Final Acceptance Punchlist

El Paso County – Department of Public Works – Stormwater Section

Project Name:	Forest Heights Estates
EDARP File Number(s):	MS206, CON2518
ESQCP Number:	ESQ2530
Attendees:	DPW SW: Shannon Mustoe DPW Development Services: Spencer Pirzadeh Developer: Phyllis Didleau, Stephan Fletcher
Date of Walk-through:	07-21-2025
Walk-through Number:	1st

FOREST HEIGHTS CIRCLE
CONSTRUCTION DRAWINGS
PLAN & PROFILE
0+00 TO 11+50

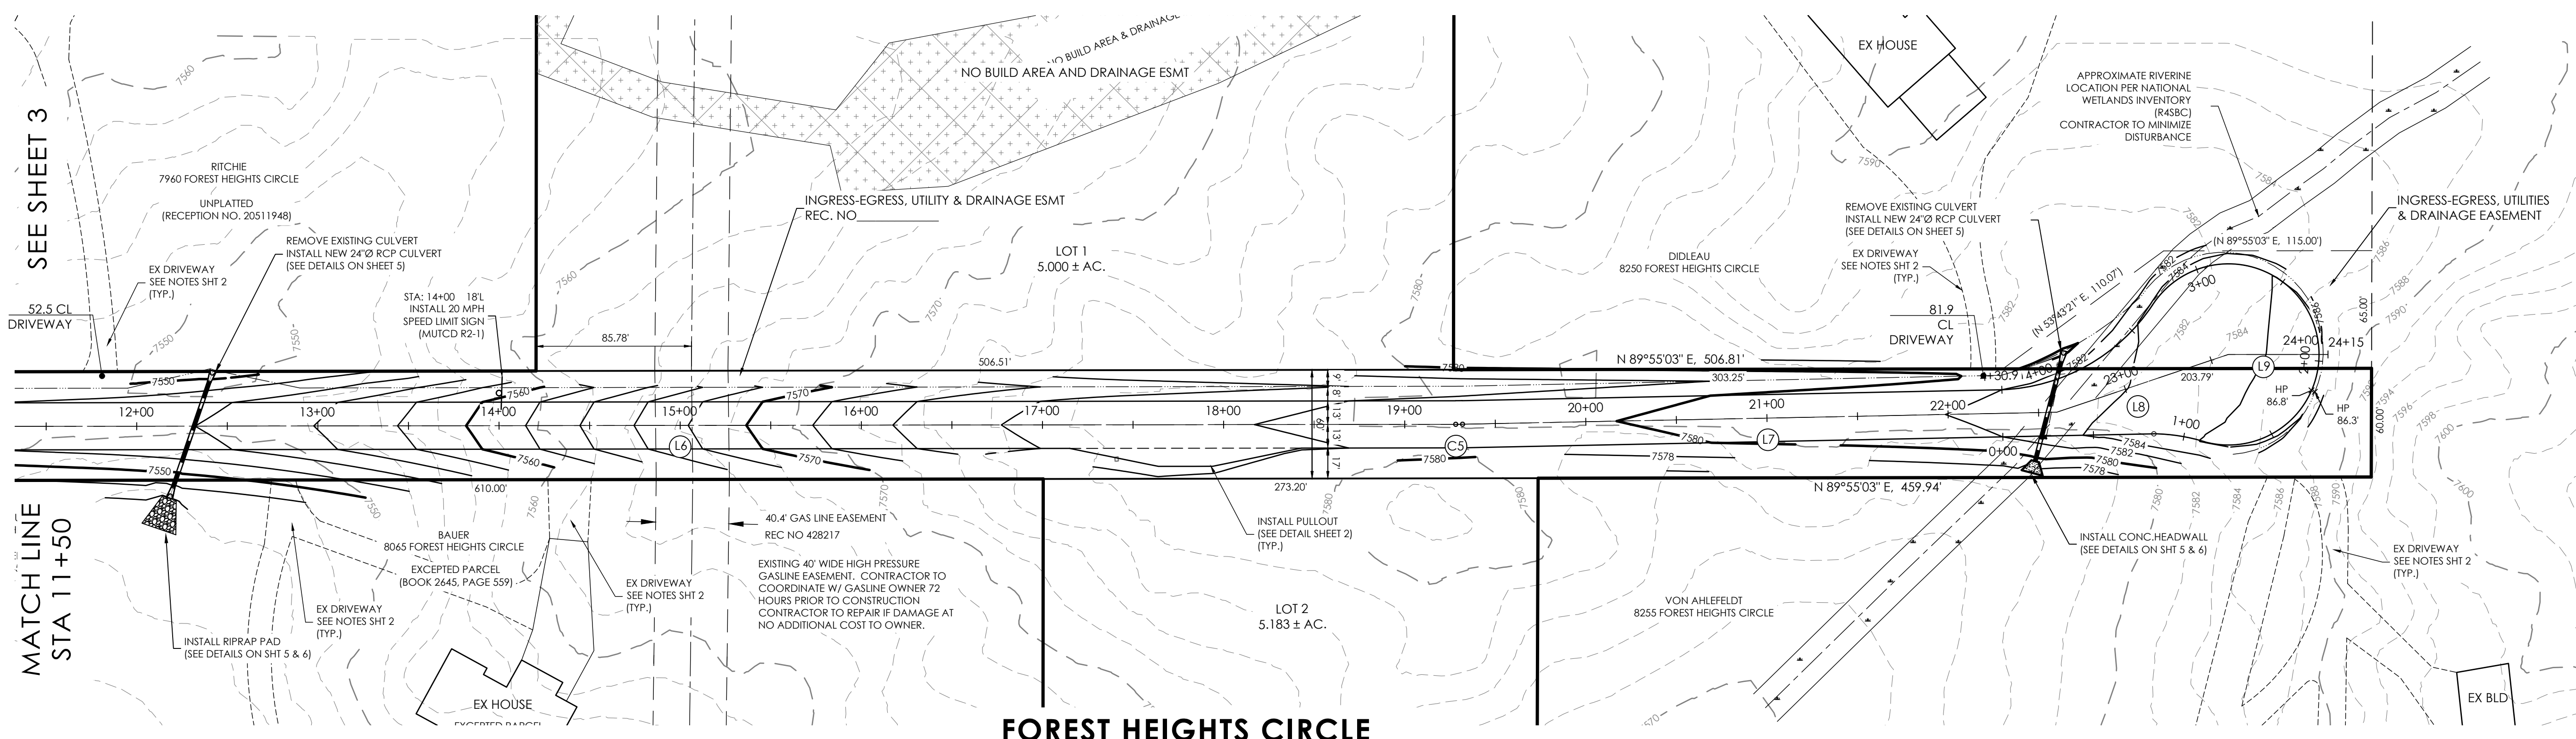
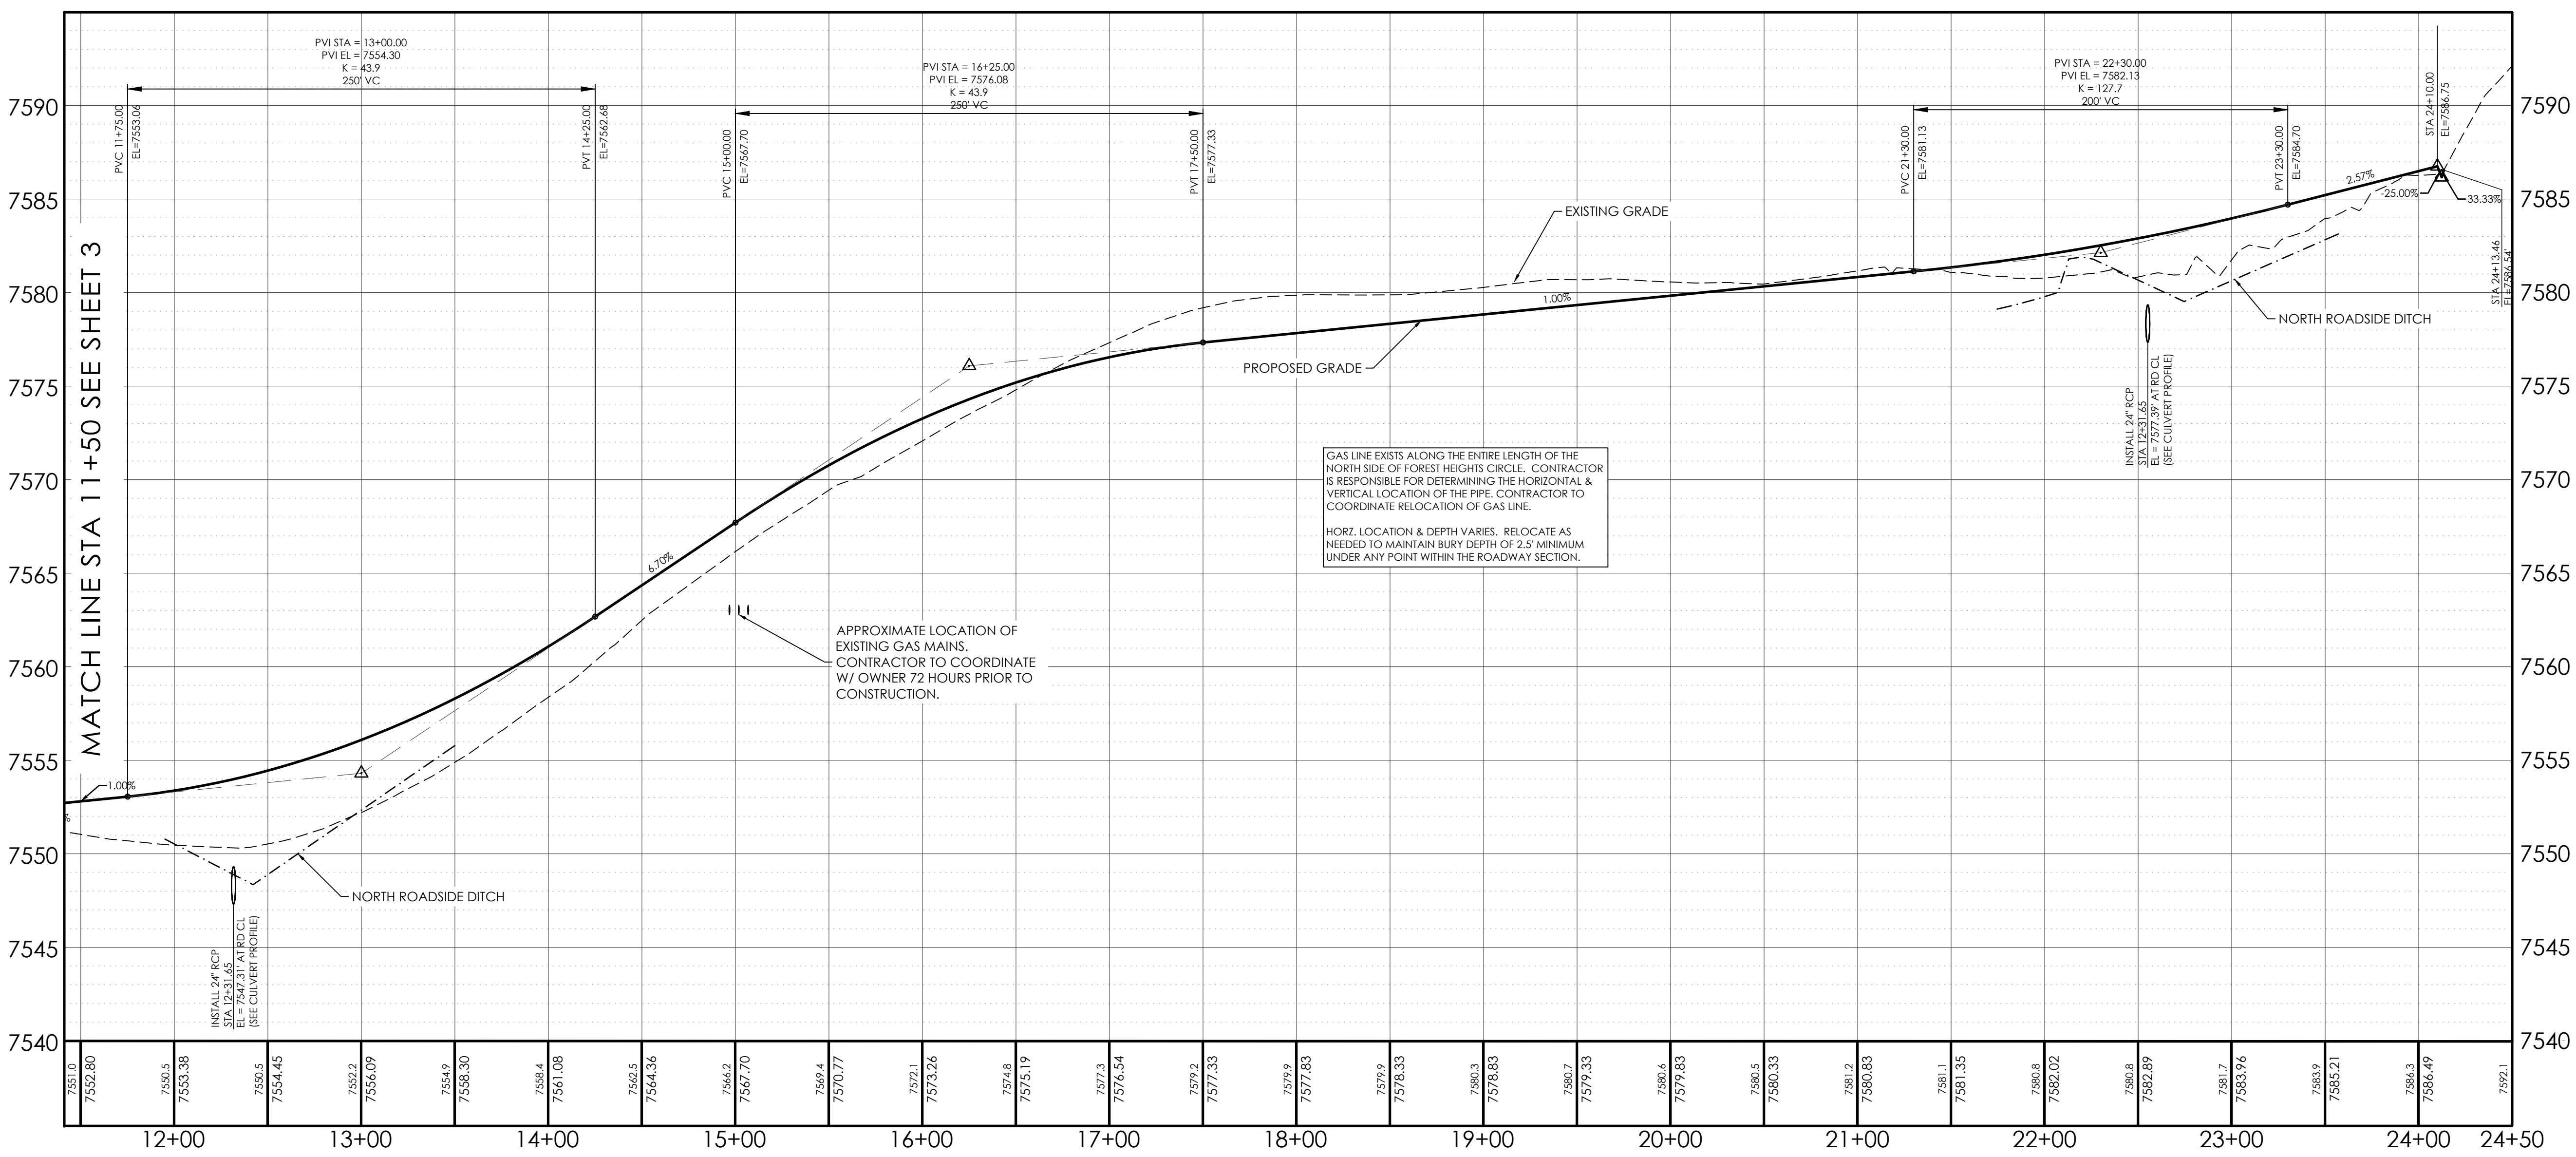
Sitewide Items [Construction Drawings Sheet 5 of 6/Grading and Erosion Control Plan Sheet 4 of 4]:

- **STA 22+55:** There is sheen present at the inflow of the new 24" culvert. Remove and properly dispose of pollutant. (Reference photo 1)
- **STA 22+55:** Water is not properly draining at new headwall, regrade to ensure there is positive drainage per approved plans. (Reference photo 2)

- **STA 22+55:** Regrade, seed and stabilize disturbed area near inflow of new 24" culvert. (Reference photo 3)
- Backfill and stabilize roadside ditch near 8250 Forest Heights Cir and stabilize per approved plans. (Reference photo 4)
- Remove and properly dispose of concrete/pollutant from new cul-de-sac. (Reference photo 5)
- **STA 1+70:** Remove and properly dispose of sediment accumulation from grouted riprap at west 18" culvert. (Reference photo 6)
- Submit a spec sheet and PO/receipt for the grass seed mix that was purchased and used.
